RE: Lot 8 Block 4 Unit 18 Volcano Cliffs 6605 Cuervo Pl NW Grading and Drainage Plan Engineers Stamp Date 6/17/15 (D10D003J8)

Lot 8 Block 4 Unit 18 Volcano Cliffs RE: 6605 Cuervo Pl NW Grading and Drainage Plan

Engineers Stamp Date 5/14/15 (D10D003J8)

GRADING & DRAINAGE PLAN
6605 Cuervo Place, NW
LOT 8, BLOCK 4, UNIT 18 VCS
 Sheet 2 of 2

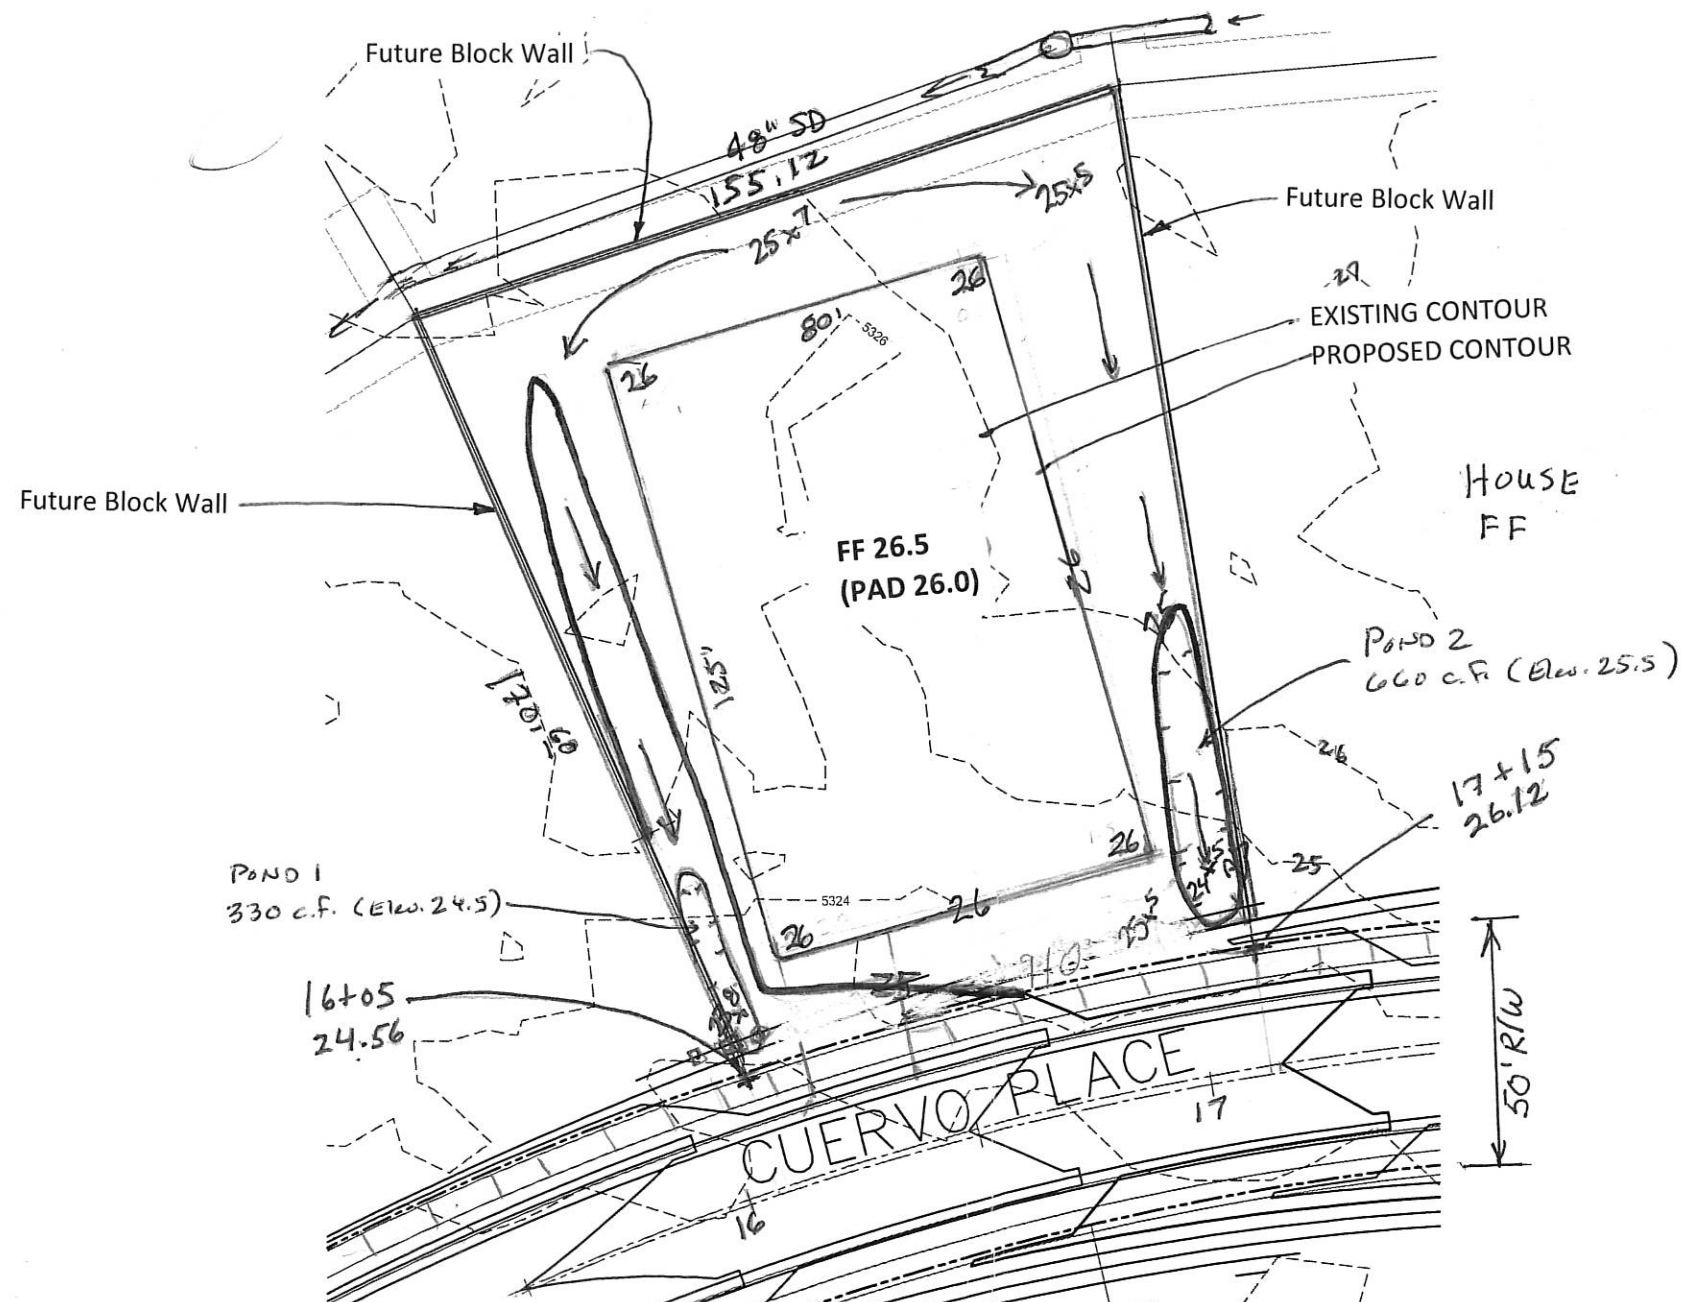
Provide pond bottoms and WSE.
Provide pond volumes.
